**WEST SUSSEX COUNTY COUNCIL
INFRASTRUCTURE CONSULTATION**

DATE: 22nd March 2010

**SUBJECT: BN/6/10 - Outline application with some matters reserved for 36 no. houses
(This application is a departure from the development plan).**

The Lillies Holiday Park, Yapton Road, Barnham, West Sussex, PO22 0AY

PROJECT	The Lillies		DATE	15/02/10
TITLE	Illustrative Site Layout		DRG NO	IBA/315/03
SCALE	1 : 500		REVISIONS	-
		Orchard House Studio 41 West Drive Aldwick Bay West Sussex PO21 4LZ Tel 01243 263241		
		www.ivonblumerarchitects.com

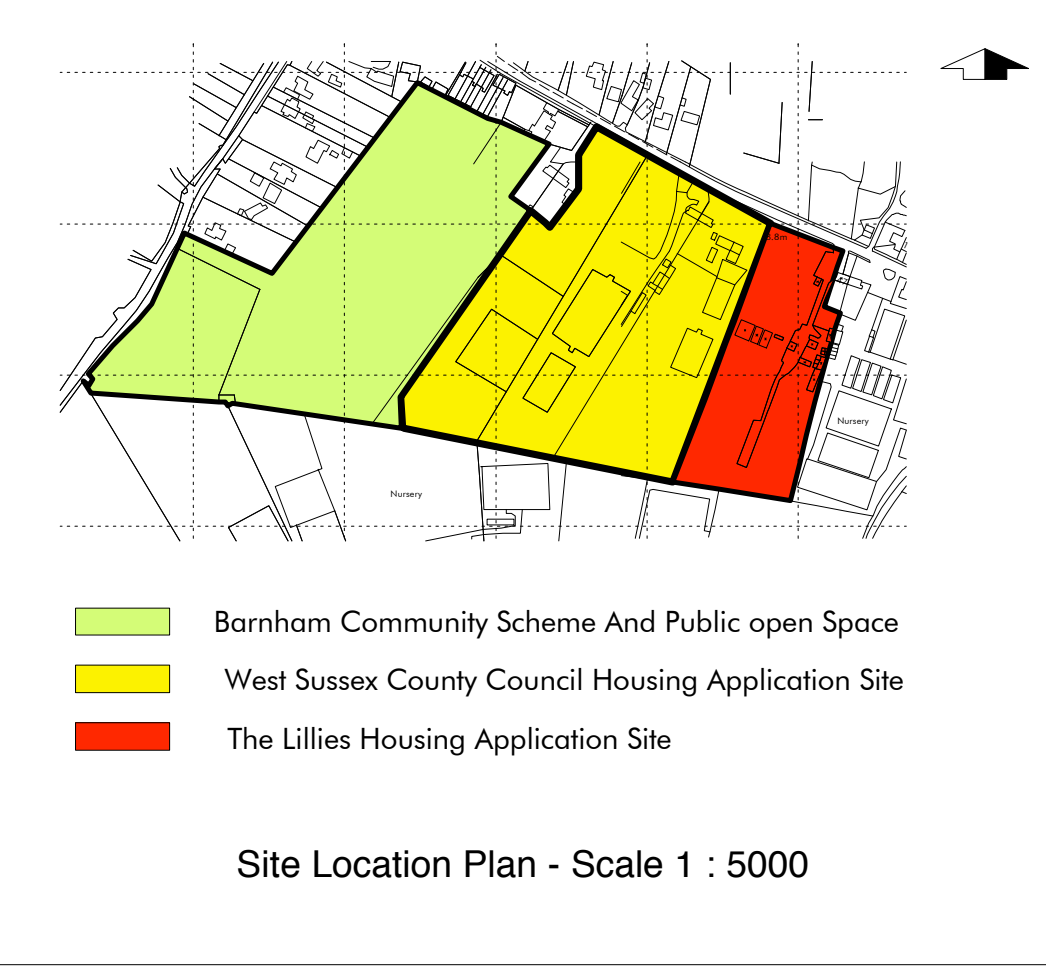
The internal layout is a reserved matter. The layout should though be based on the advice within Manual for Streets. The proposed parking provision (of 102 spaces) is within the WSCC Parking Standards, with the layout for parking considered as part of the reserved matters application. Pedestrian/cyclist links are shown between the application site and that on the neighbouring land, such links would increase permeability and as such these would be beneficial. The Developers of the respective sites should liaise with one another to develop such links through any reserved matters applications.
